## PLANNING CONSULTATION RESPONSE

| <b>Application No</b>             | <u>2026/0121</u>                                                                     |
| <b>Proposal</b>                   | Creation of an access and the erection of a raised parking platform with under build |
| <b>Address</b>                    | 33 Old Mill Lane, Barnsley, S71 1PS                                                  |

**TYPICAL SECTION**

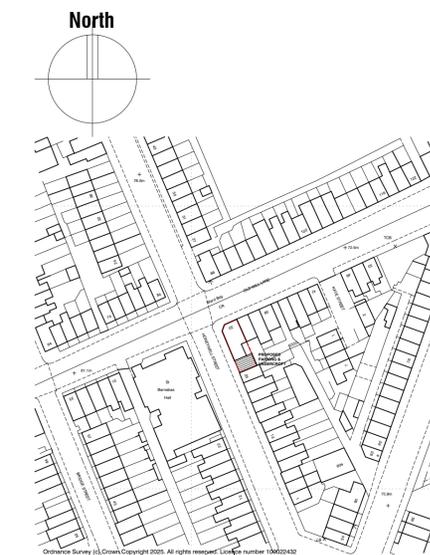
*As the wall will be retaining the adopted highway, it will need to go through the full Highway Structures Technical Approval Process required for the proposed retained height.*

*Given that the retained height appears to be approximately 2.69m when scaled from the submitted plans, it is considered that a full Approval in Principle in accordance with CG 300 of the DMRB will be required. Furthermore, the wall will need to be designed for vehicular loading, as the proposed development includes the provision of a parking space immediately adjacent to and above the structure.*

*The proposal involves excavation for new foundations immediately adjacent to the existing retaining wall, together with the creation of a vehicular access and parking area above. This will impose*

*additional loading on the wall, which cannot be assumed to have been designed to accommodate such loads, particularly where it is retaining the adopted highway.*

In the absence of this information, it has not been demonstrated that the proposed development would not adversely affect the stability or integrity of the retaining structure supporting the adopted highway.

*It is therefore essential that the required structural assessments are submitted and agreed prior to determination of the application.*
